Your ref:
Our ref: 23/00237/F
Please ask for: Luke Swales
Direct dial: 01553 616865
E-mail: borough.planning@west-norfolk.gov.uk

16 February 2023

Details: **Proposed single and two storey extension. at Ivy House West Drove South
Walpole Highway Wisbech Norfolk**

DRAWING NUMBER 533.PD2.01

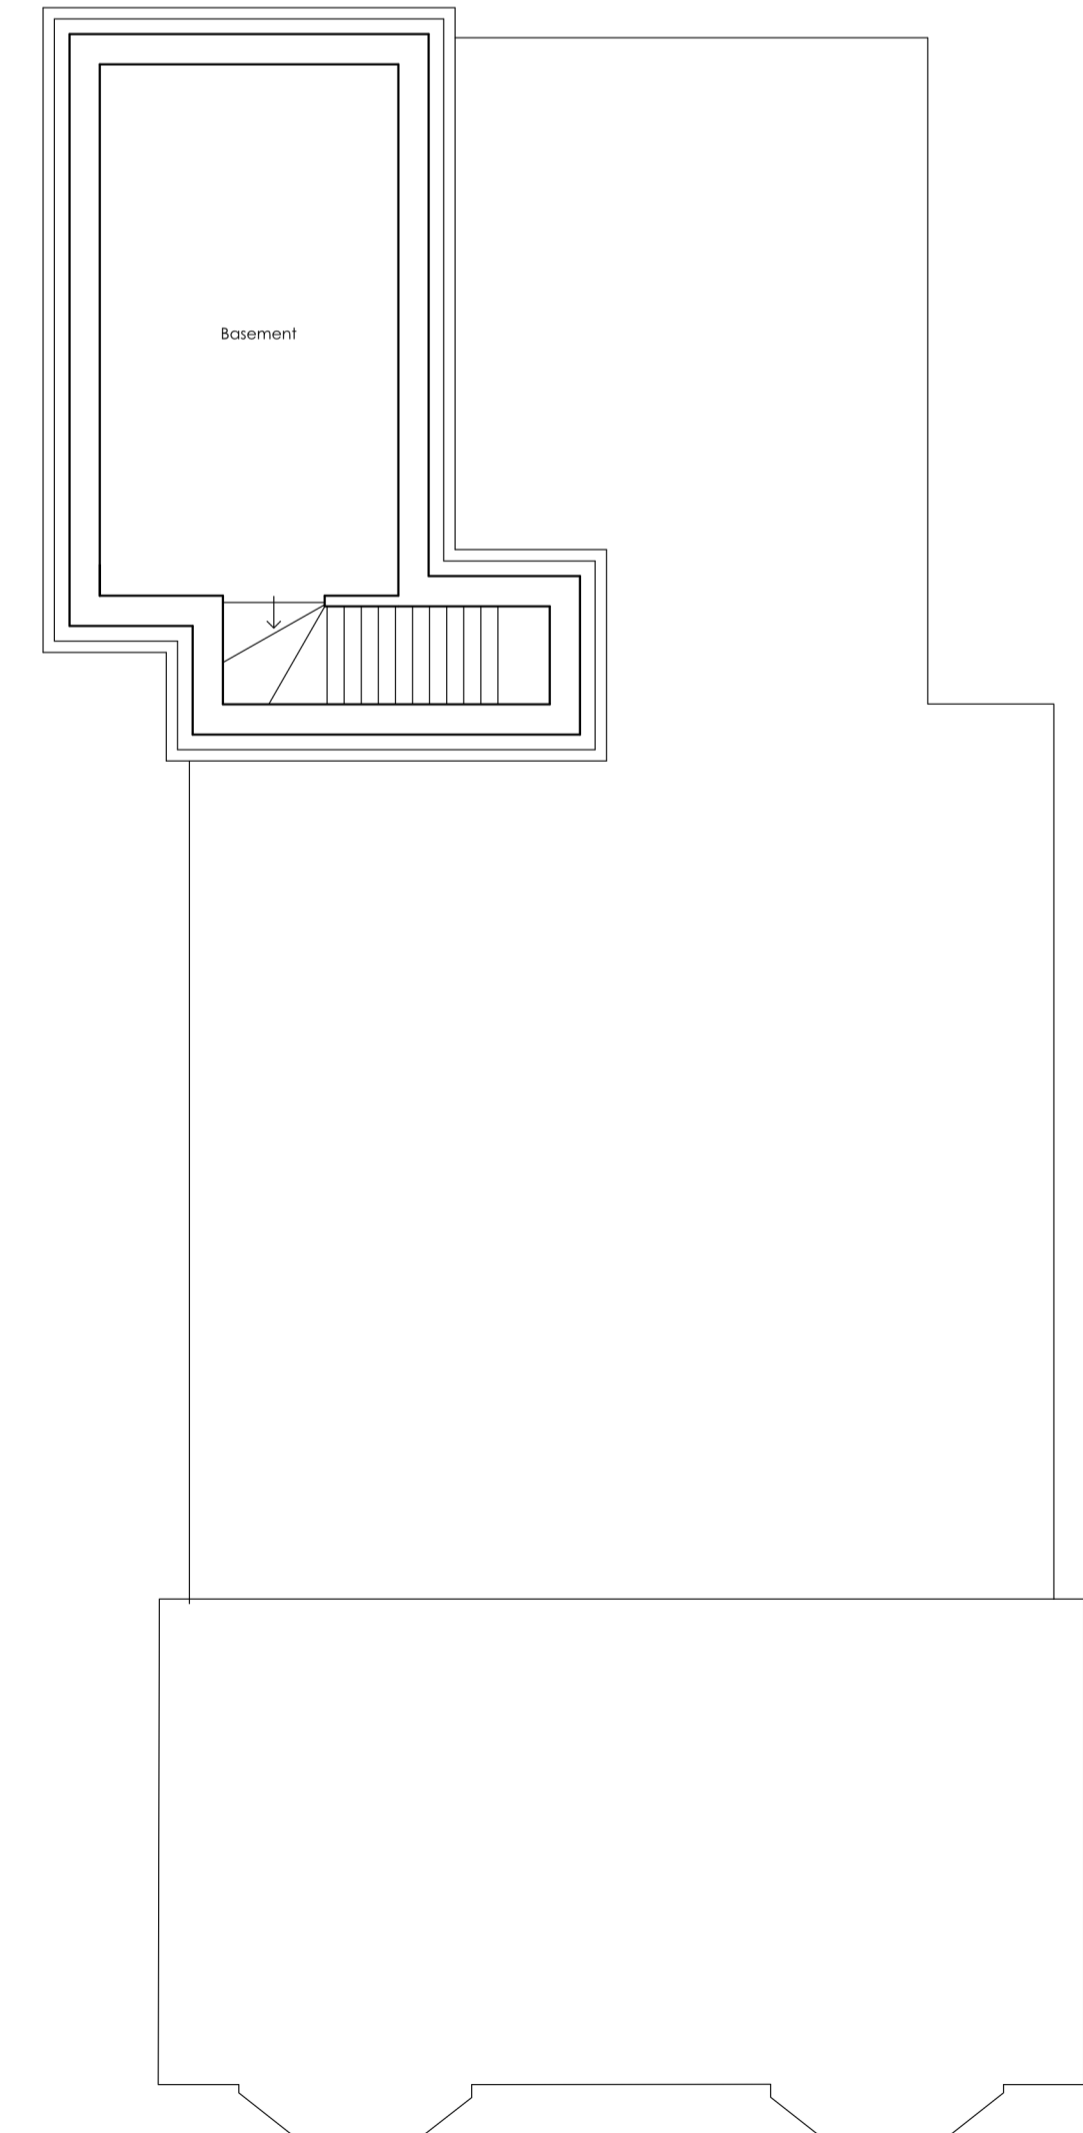
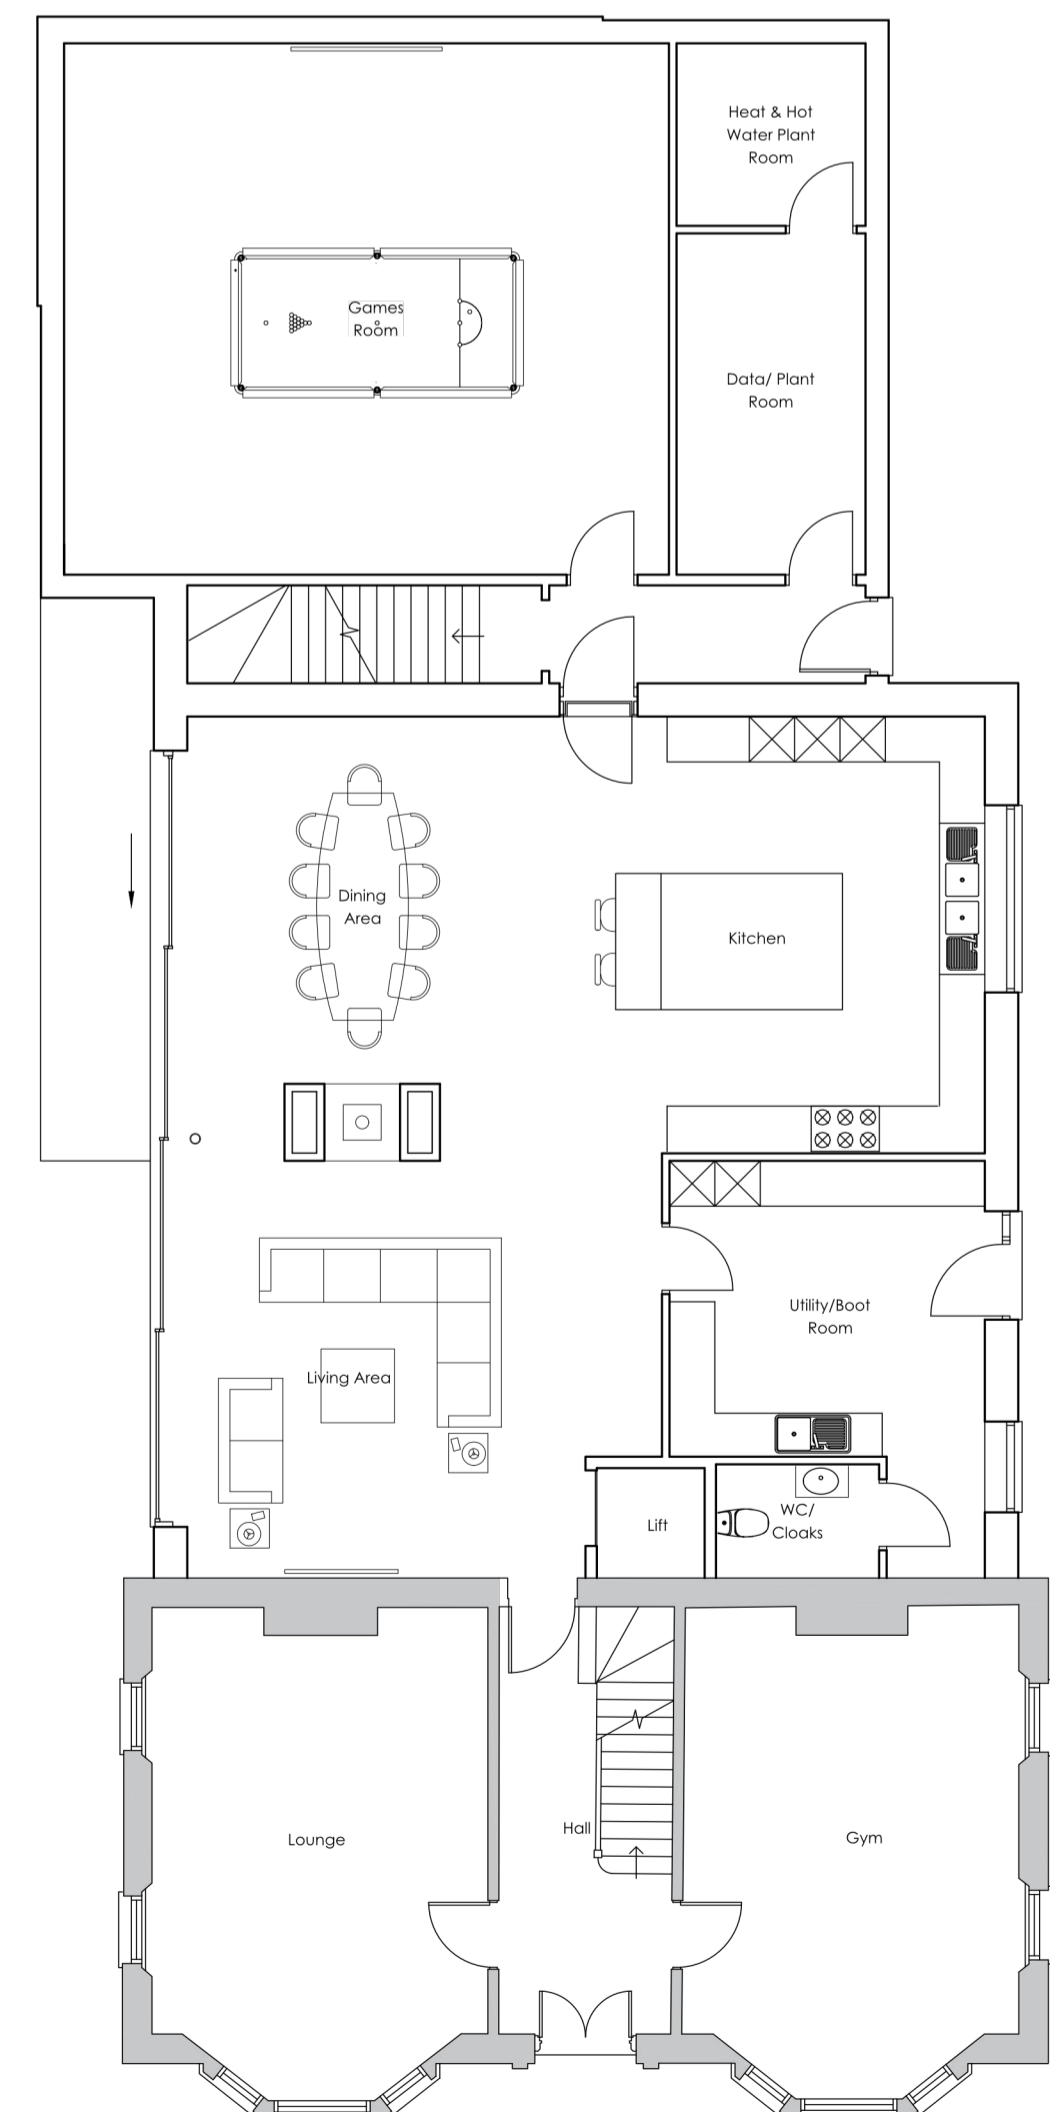
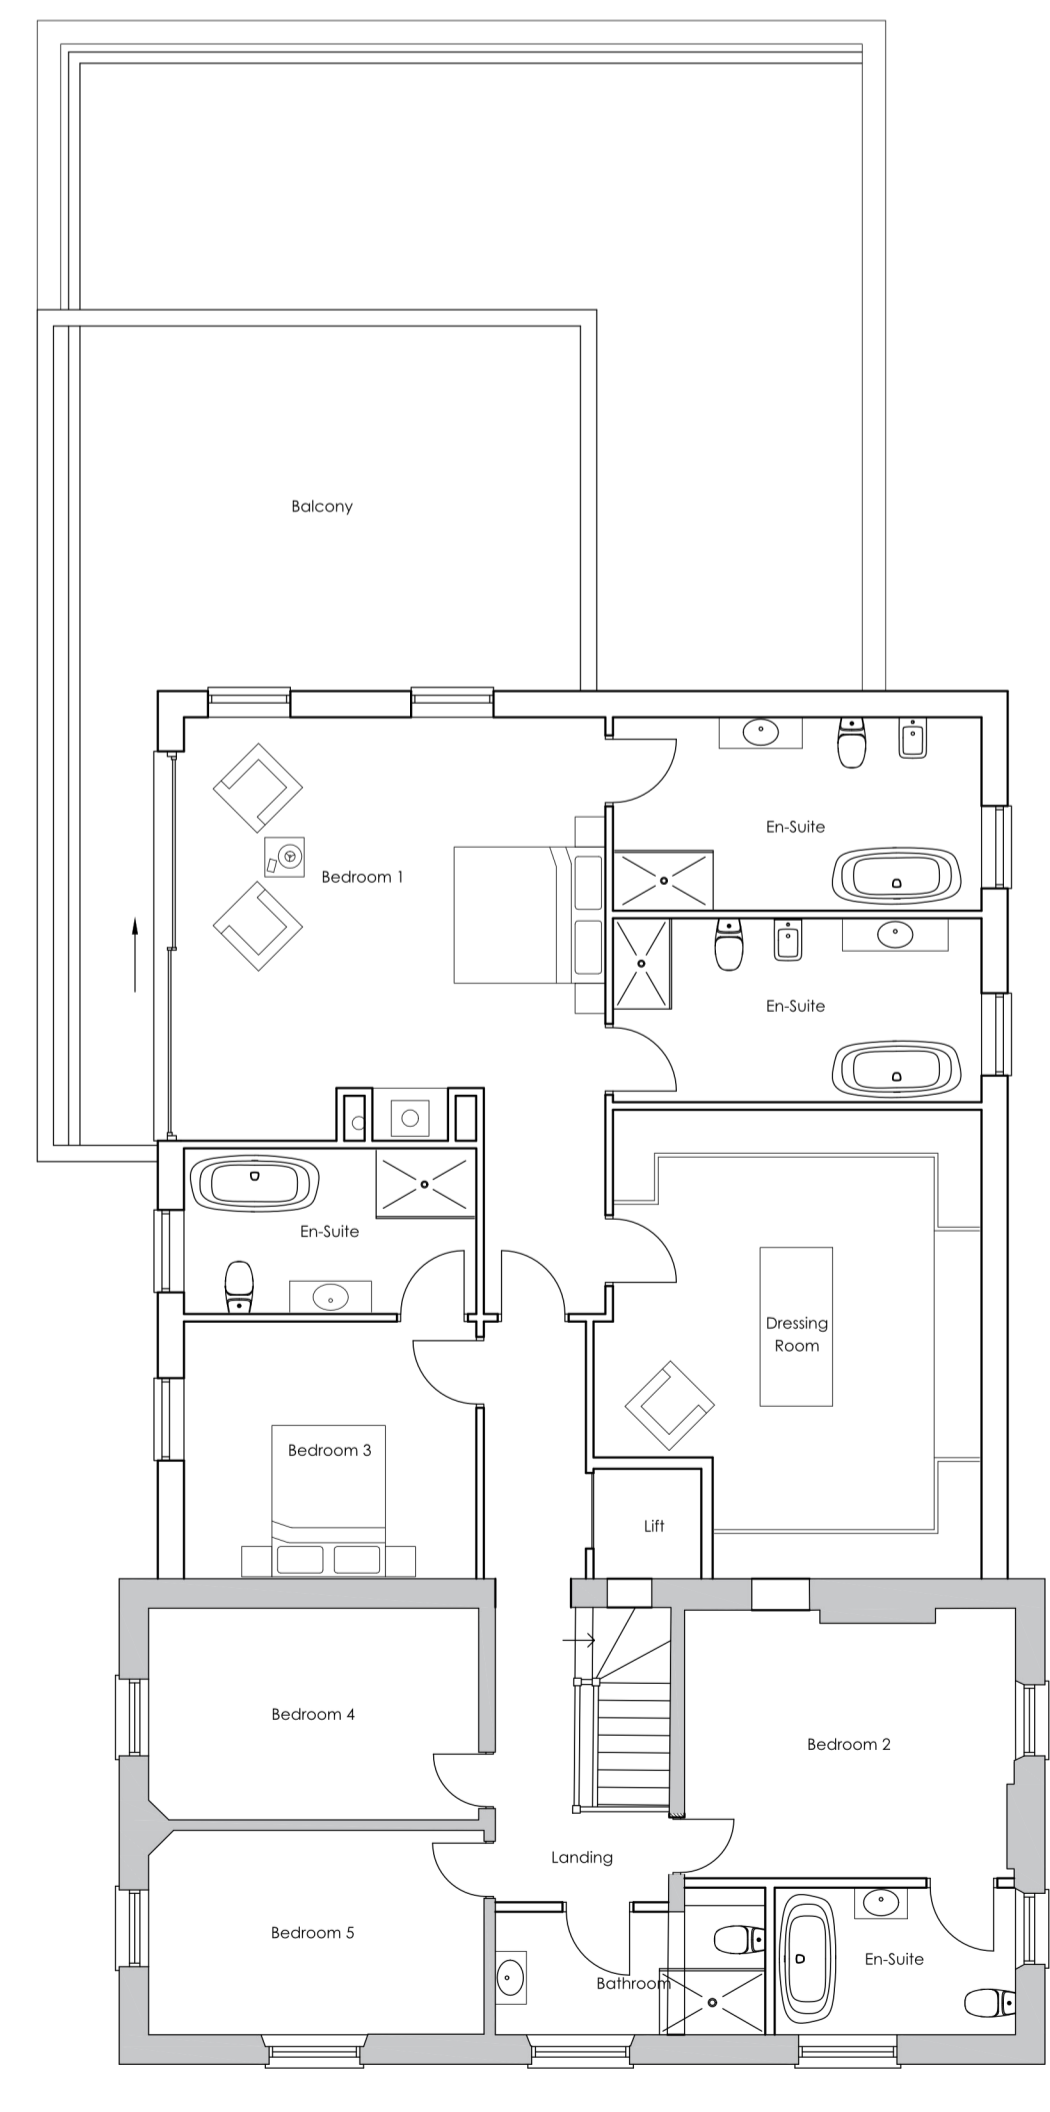
1. Please provide four copies of a drawing, to a recognisable scale, showing a section through the new extension.
2. In accordance with the National Validation Checklist, which became mandatory on 6 May 2008, we will require information regarding site levels. If site levels are to change, please provide four copies of a site survey drawing, alternatively, if site levels are to remain unchanged, this can be annotated on the relevant plan or advised in writing.
3. On your drawing it says "Do not scale directly from this drawing." As part of the national validation checklist all drawings must be true to their stated scales, therefore please amend the drawings to remove this.
